## REQUEST

## SUMMARY OF PETITION

The petition proposes to allow expansion of a parking area to support uses permitted in the MUDD district in the adaptive reuse of a building in the Enderly Park neighborhood.

## STAFF RECOMMENDATION

REZONING PLAN

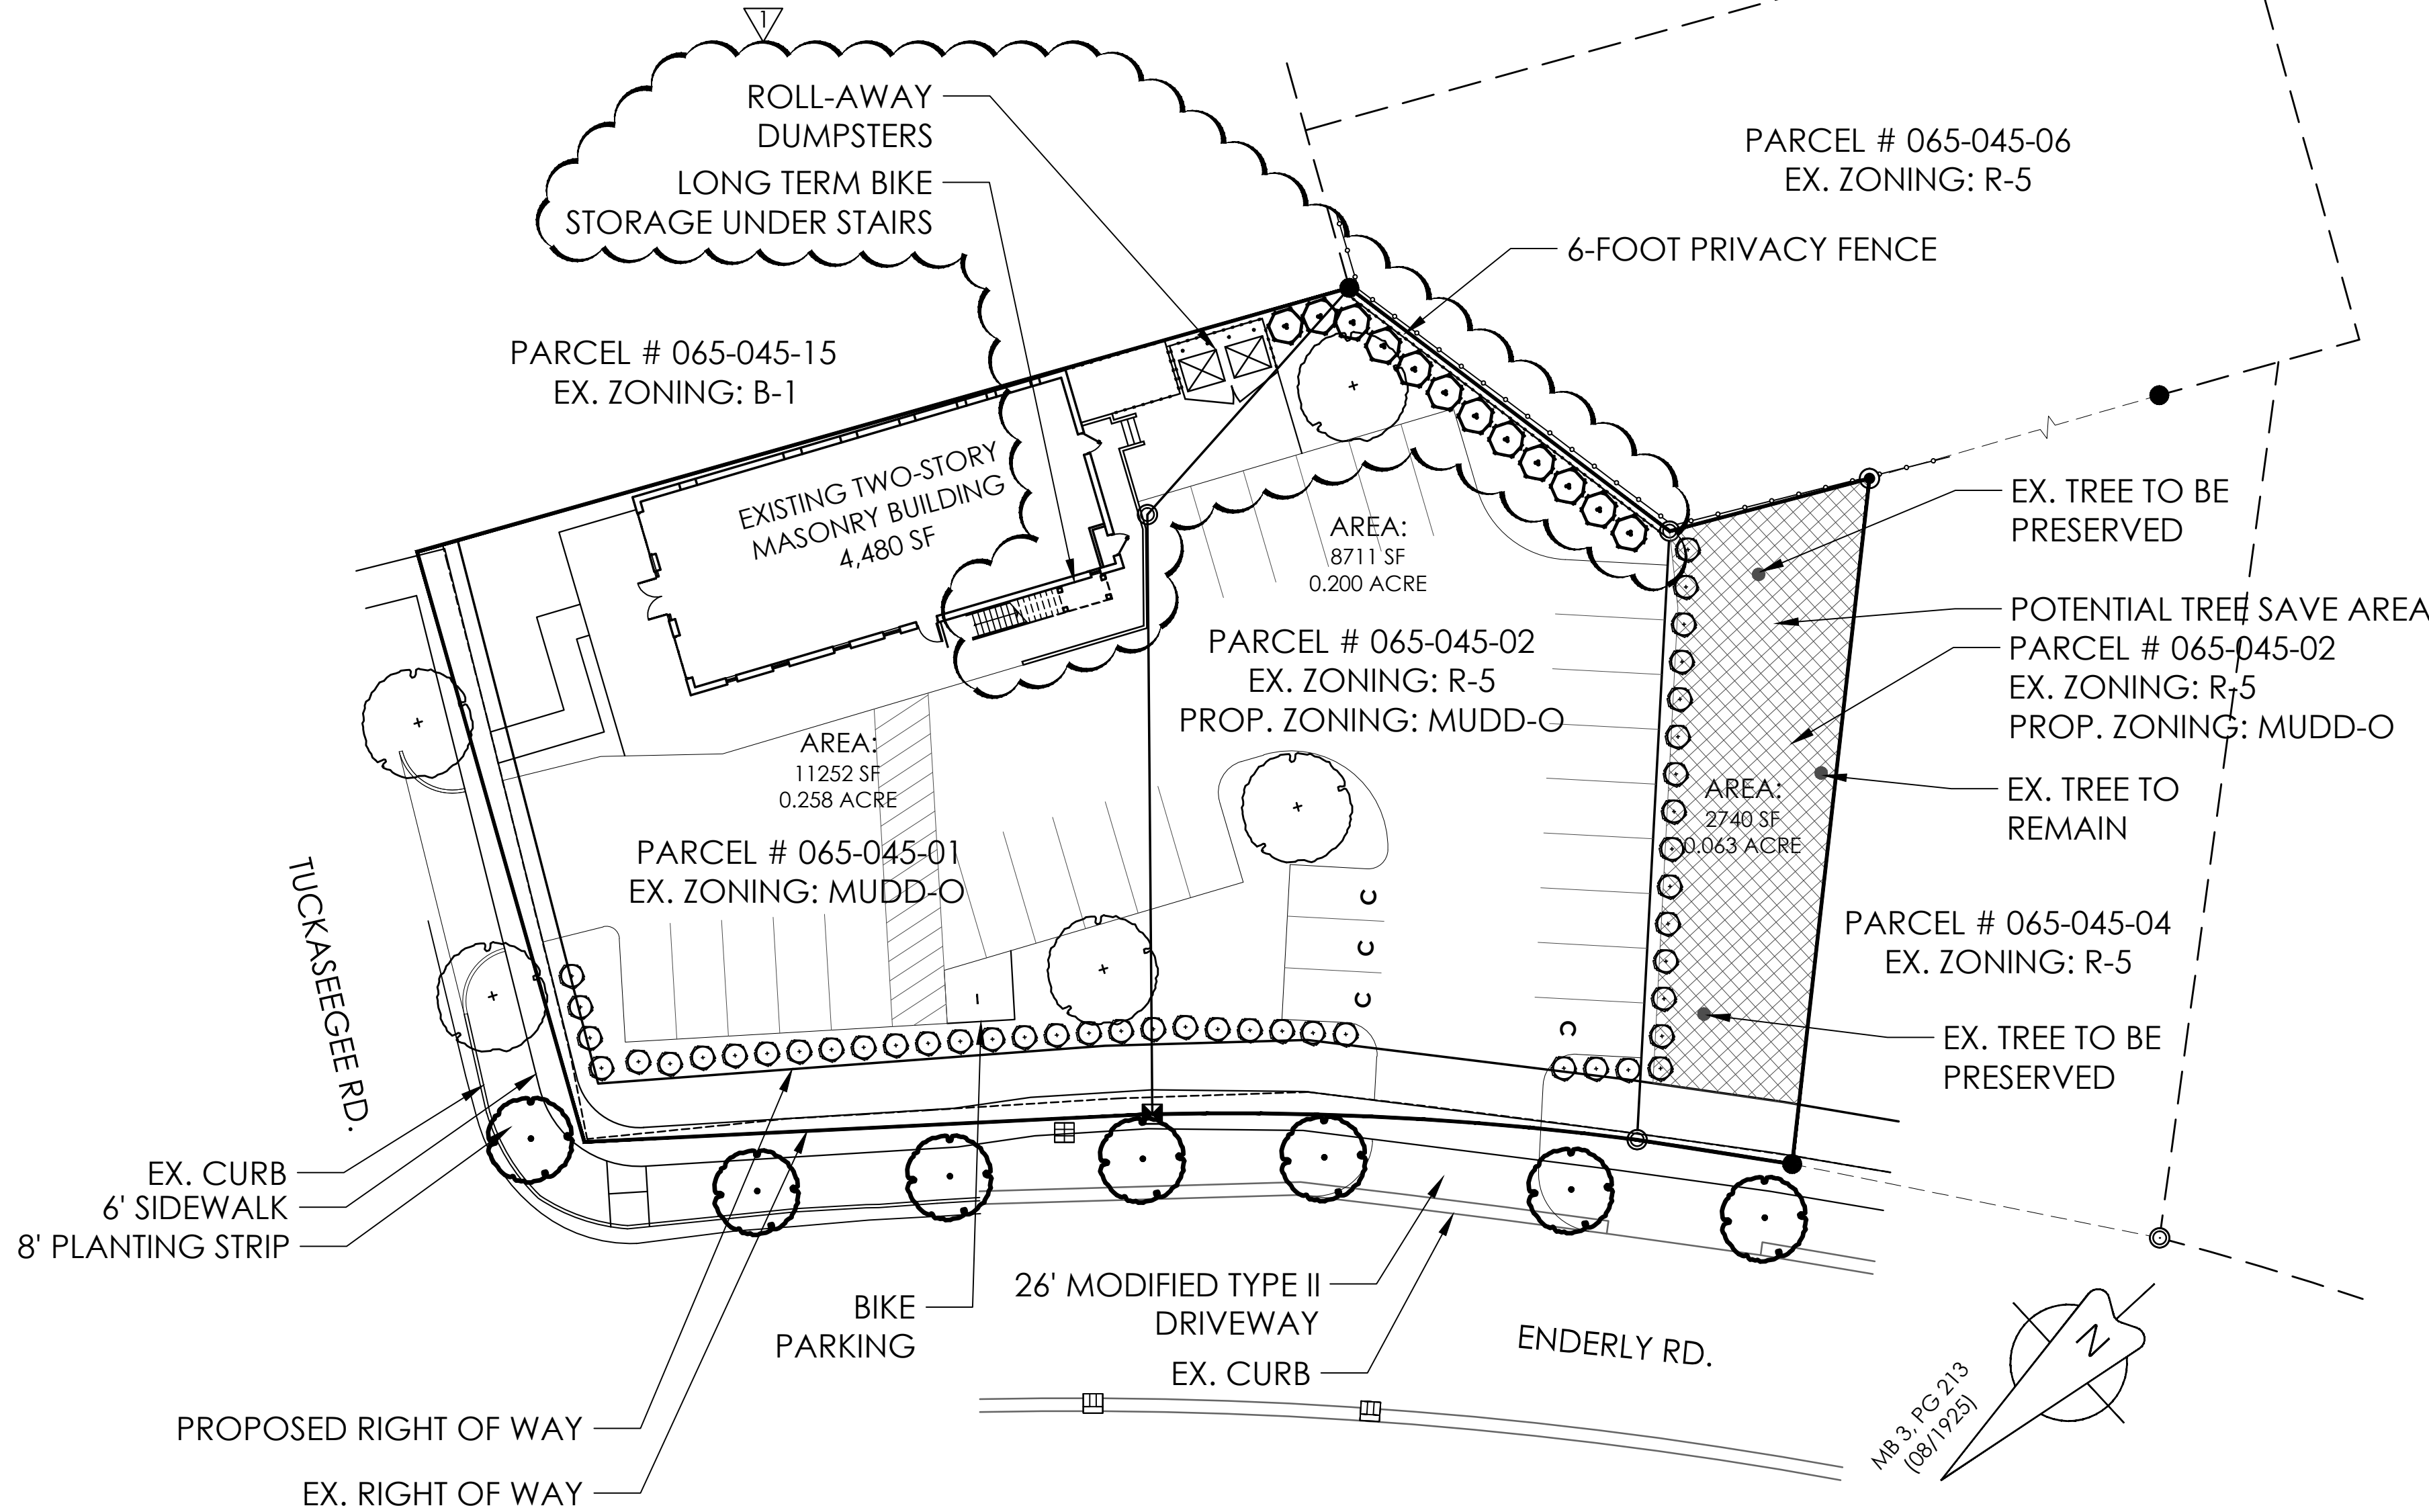
1. Add a conditional note stating that the existing two-story commercial structure will remain and not be expanded and that no other building may be constructed.
2. Clarify that note 2 under Optional Provisions applies only to the existing two-story commercial structure.
3. Remove note 3 under Optional Provisions.
